**Consultation Response from Mike Hibbert,
KC Waste Strategy(Refuse & Recycling)**

2023/92490 Former Dowker Works, Dowker Street, Milnsbridge, Huddersfield, HD3 4JX

Erection of 38 dwellings with associated access and landscaping (within a Conservation Area)

Responding Ref: WPS 23-050

Proposed Site Plan
1 : 200

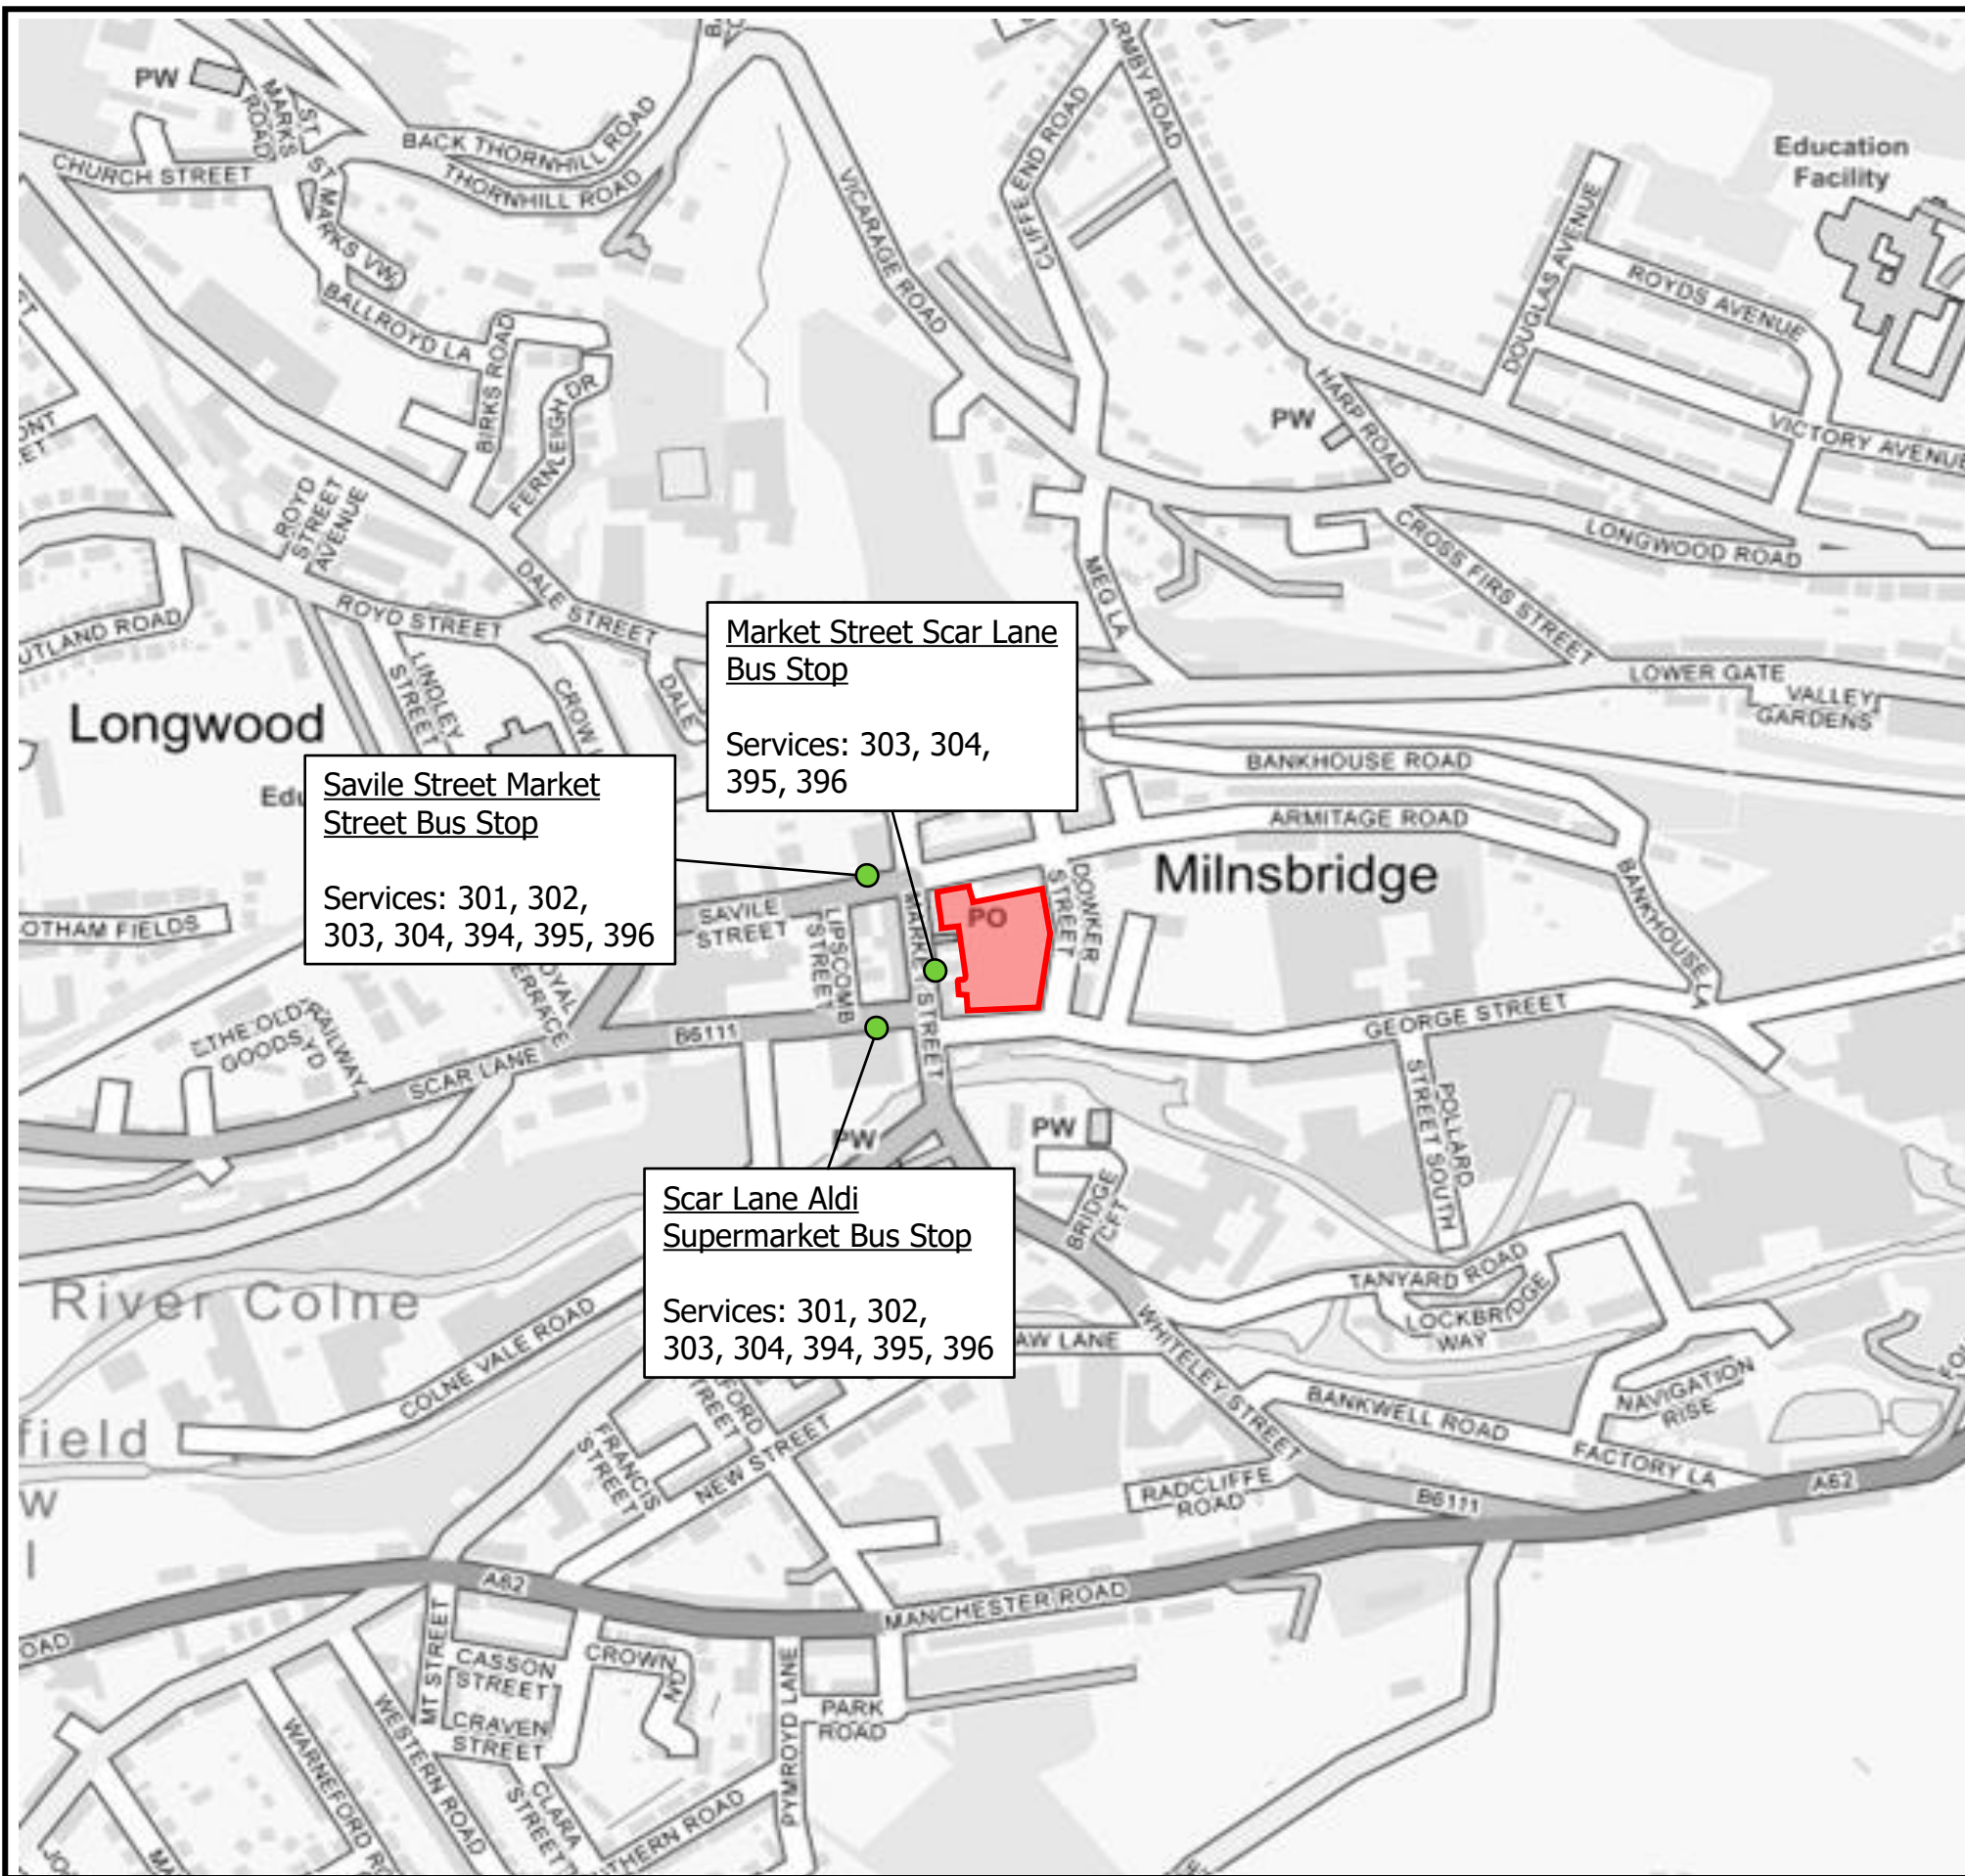
- It is welcomed that Plots 7 to 16 and 35 to 38 are provided with storage space for 3x 240ltrs wheeliebins in the rear gardens of properties. Pathways and gates appear to be wide enough for 240ltrs wheeliebins to pass through. No details are shown as to the location of Bin Collection Points (BCP's) for these properties. The route from the bin store to the highway for Plot 8 is convoluted but this arrangement is preferable to storage at the front of the property.

- A communal bin store (No1) and a BCP for Plots 1-6, consisting of 2x1100ltrs wheeliebins, is shown adjacent to Armitage Road. Location of the gate is such that both bins must be removed to be able to get the back bin out the store.
- A communal bin store (No2) and a BCP for Plots 18 to 21 consisting of 4x1100ltrs wheeliebins, is shown adjacent to the internal access road.
- A communal bin store (No3) and a BCP for Plots 29 to 34 consisting of 4x1100ltrs wheeliebins, is shown to the south of Plots 35 and 36 and adjacent to the internal access road. The access route between Store 3 and the BCP appears to require traversing the car parking place for Plot 25.
- A communal bin store (No4) and a BCP for Plots 23 to 28 consisting of 2x1100ltrs wheeliebins, is shown close to the junction of Dowker Street and George Street. The bins are contained in a purpose design store.

From the plan it appears that wheeliebins cannot be removed individually from the store due to configuration of the door alignment.

- The wheeliebins on the plans appear to have dimensions of 1600mm x 950mm. Guidance indicates the floor space for a 1100ltrs wheeliebin is 1575mmx1190mm with space to manoeuvre the bins within the store. Bin store dimensions depend on

configuration within the store. The bin stores appear to be large enough to accommodate the bins however the width of the access gate to the stores are approximately 850mm that is too narrow for a wheeliebin to pass through. Location of the gates in some cases is such that a number of bins must be removed to be able to get the back bin out the store. The bin storage area and access routes to the Bin Collection Point (BCP) should be constructed to withstand point loading and movement, impacts of larger bins over time, and to resist future rutting, pitting, cracking or other such surface degradation that would impair bin manoeuvring. To facilitate loading of full wheeliebins the surface between the bin store and BCP/ highway should be smooth hard surface without kerbs.

- Bin store presents a fire risk. Guidance indicates communal bin stores should be 6m from buildings unless designed to comply with fire regulations (refer to BS 5906:2005 Waste Management in Buildings; Building Regs 2010 Part H6 and CFPA-E Guideline No 7:2022 F).
- The waste store should be secure to prevent theft, unauthorised use/ fly tipping or rough sleeping. If the doors to the bin store are to have a keypad to secure access these details will be required by the collection staff.
